Our Ref: BR/128/20/DOC

Approval of details reserved by condition imposed under BR/219/18/PL for condition 4-surface water drainage; 5-colour schedule of materials & finishes, 6-dustbin enclosures details; 7-electrical vehicle charging points, 8-incorporation of decentralised, renewable, low carbon energy supply system, 9-vehicular access details & 11-cycle parking space details.

9 Westloats Lane Bognor Regis PO21 5JZ

Sheet
 1A

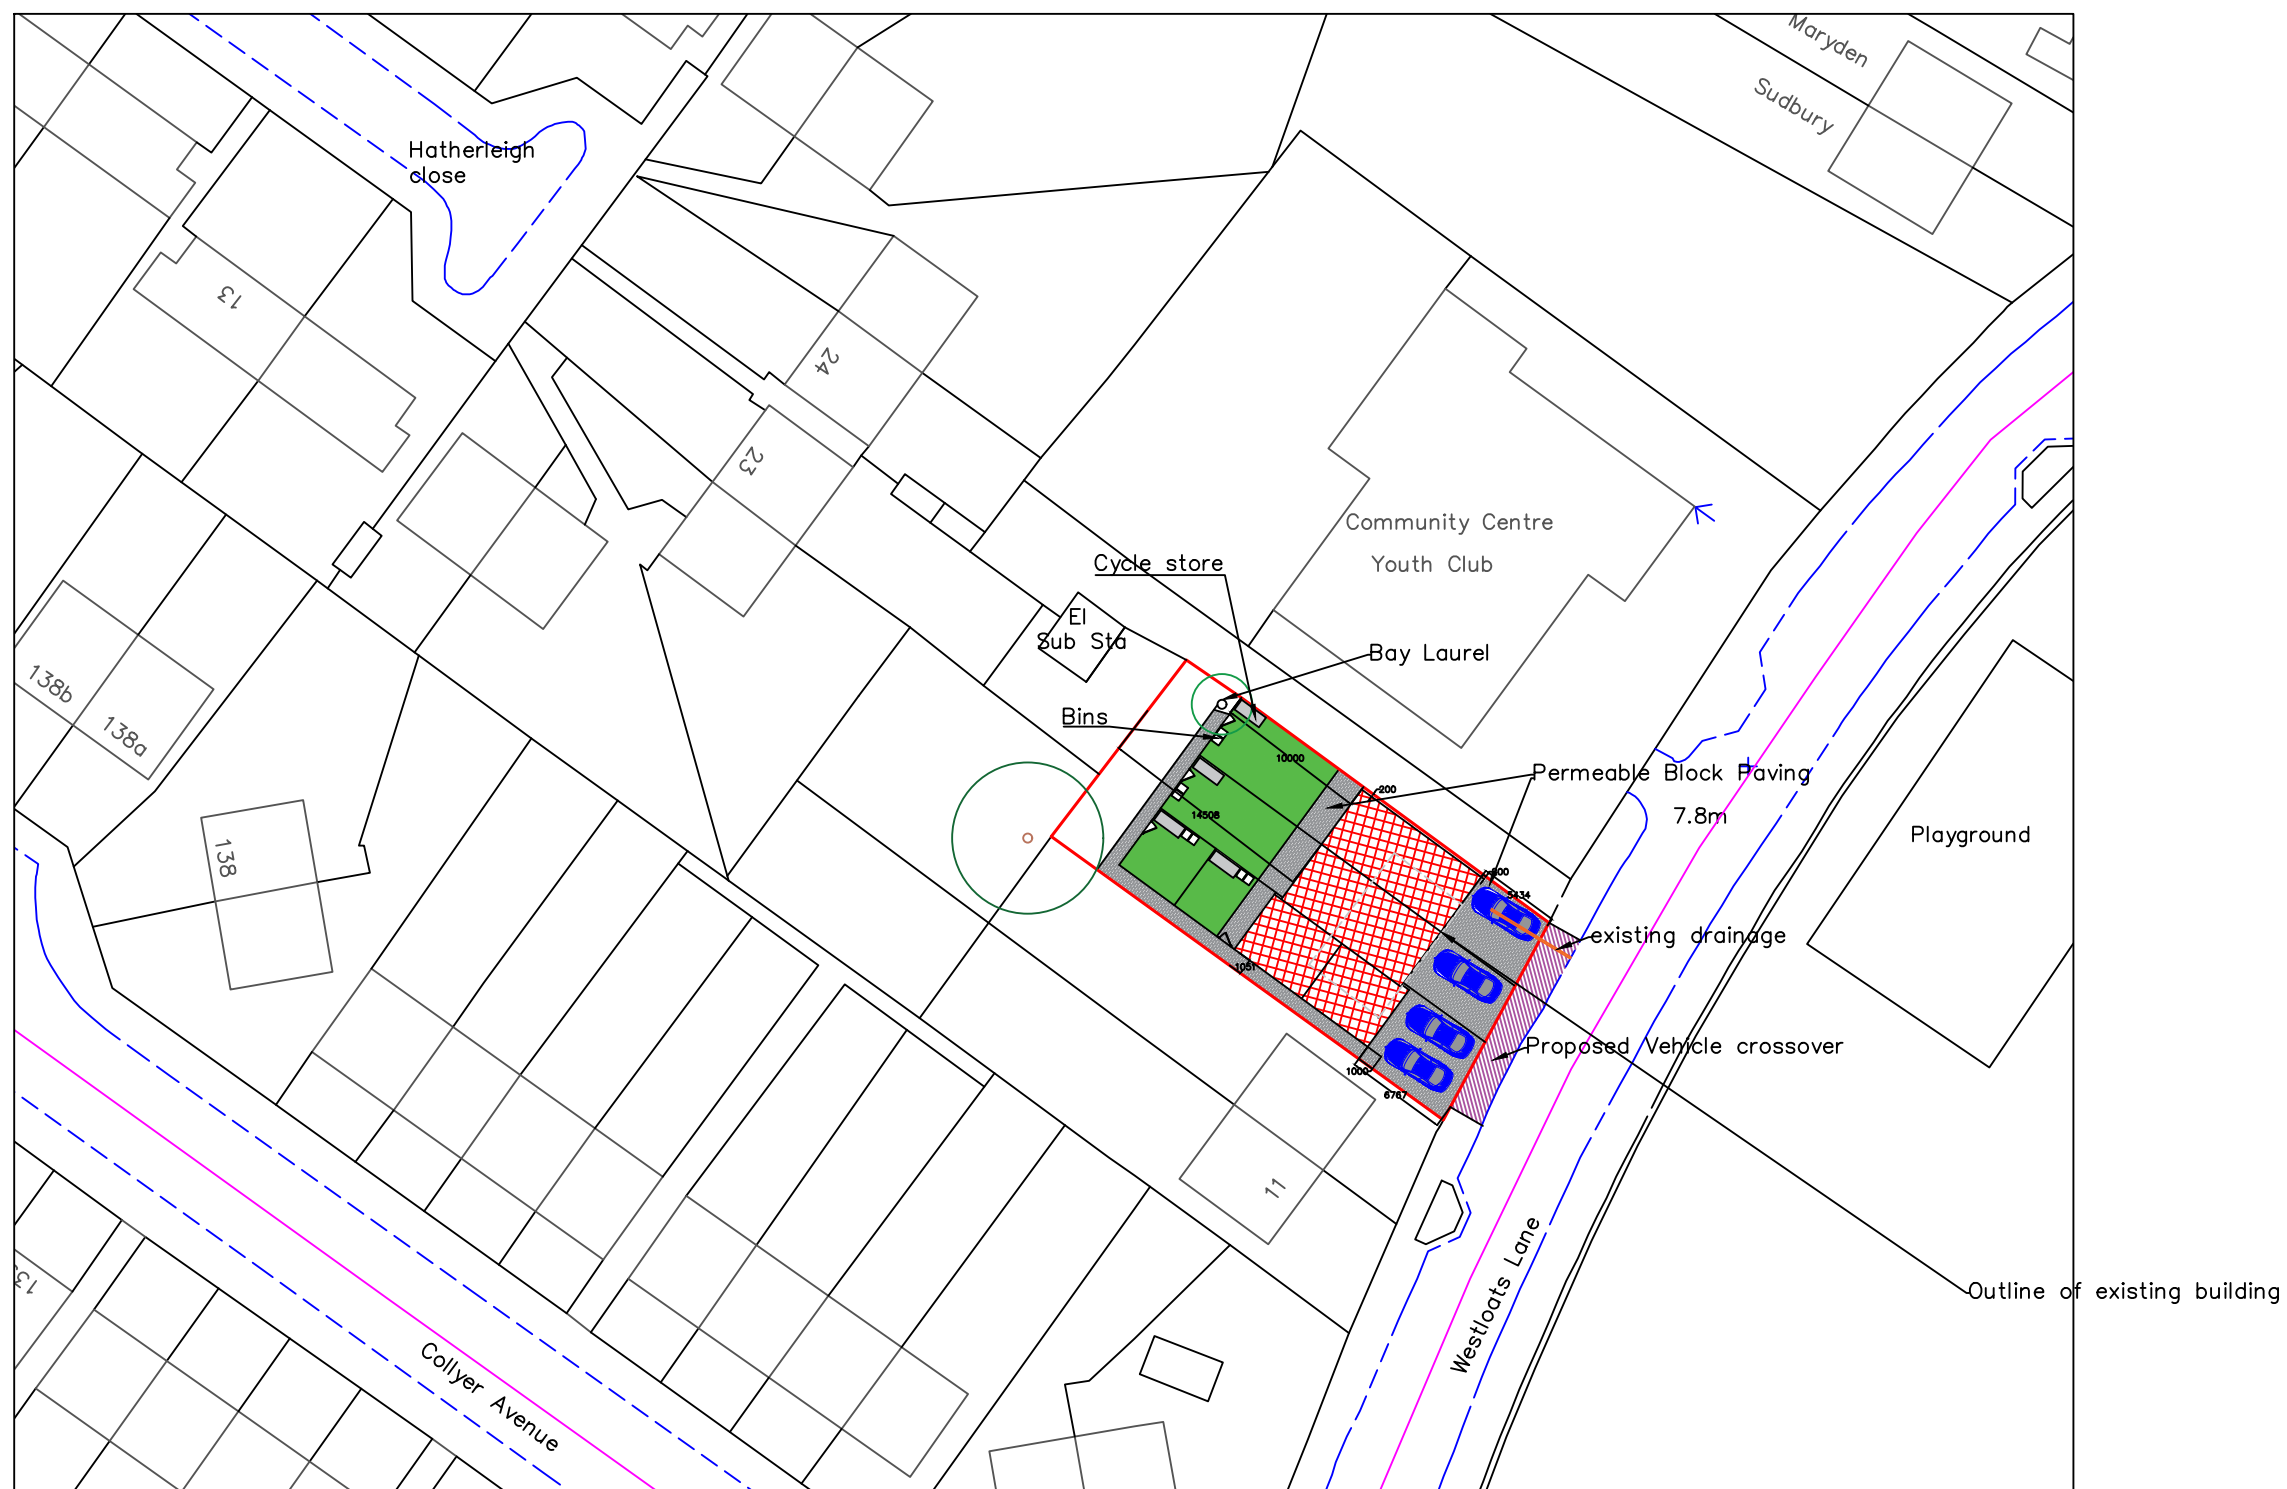
The submitted site plan (Sheet 2A) indicates that a vehicular crossover (VCO) of approximately 13.8m width will be provided for the proposed four dwellings. The LHA is satisfied with the proposed width and

details provided. The applicant is reminded that the VCO is subject to licence from the West Sussex Area Engineer and must be constructed to a specification agreed with them.

The condition is therefore fully discharged on the understanding that the VCO will be constructed in accordance with submitted plan and that it will be permanently retained in a condition that is fit for purpose.
